Our Ref: 20/01011/FUL
Your Ref:
2339_Copnor_Extension

LOCATION: Tesco's, 241 Copnor Road, Portsmouth, PO3 5EE,

PROPOSAL: Installation of Modular Extension With Insulated Prefabricated Panel Walls and Metal Roof Deck **(20/01011/FUL)**

CONTENT
PROPOSED ELEVATIONS

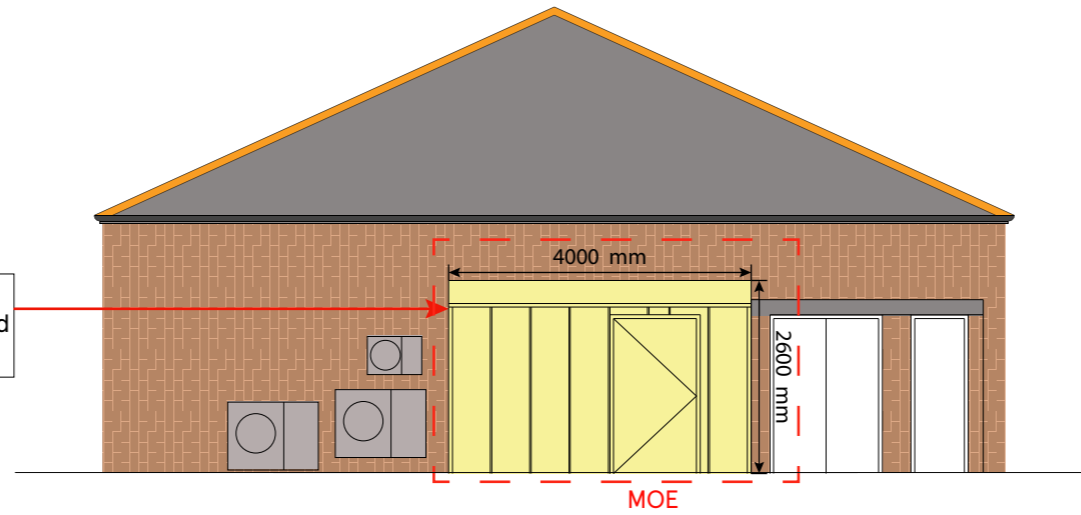
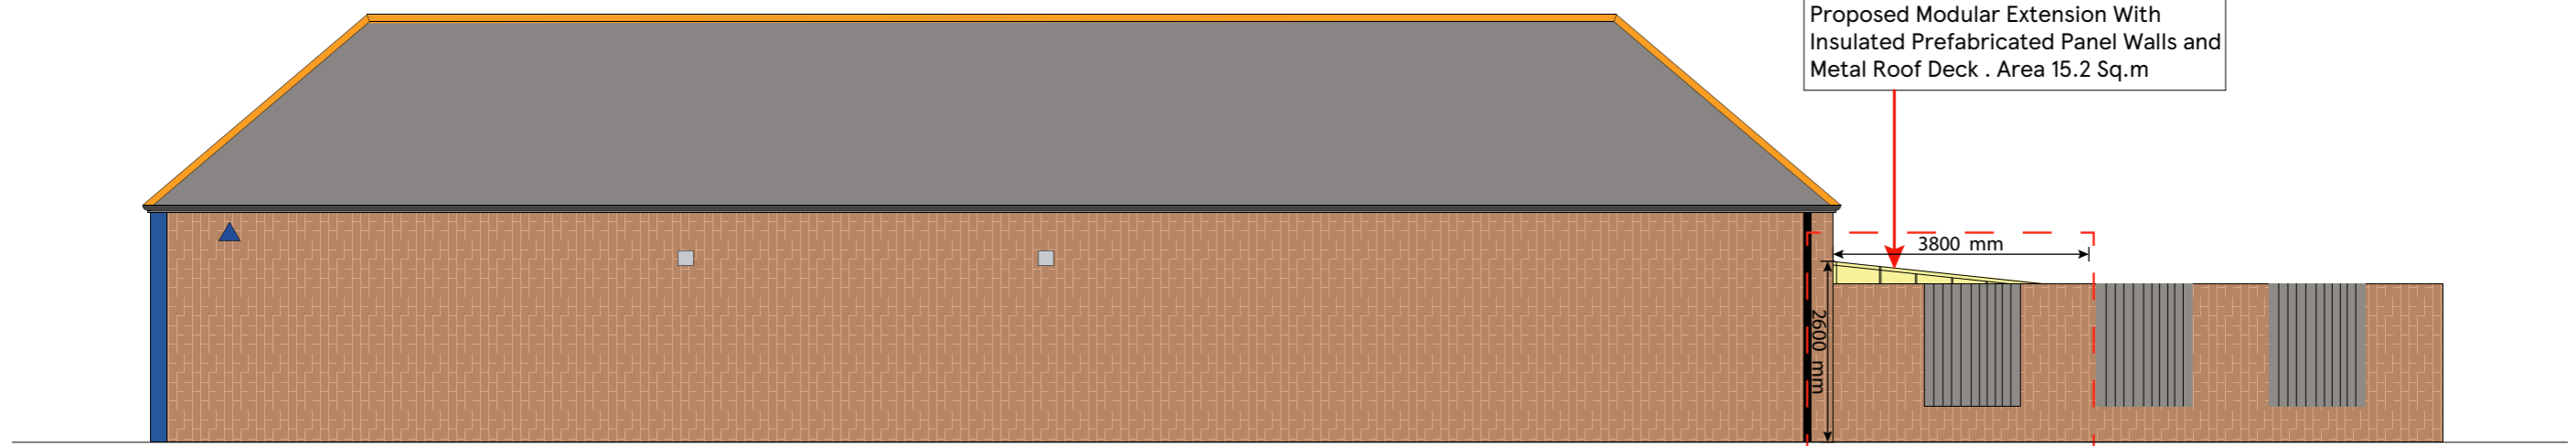
- 1) A proposed four elevation drawing of the modular extension is required at a scale of 1:100 or 1:50, including dimensions or a scale ruler. (Clearly needs to show all windows and doors without fencing in the way).
- 2) An existing four elevation drawing of the structure is required at a scale of 1:100 or 1:50, including dimensions or a scale ruler.
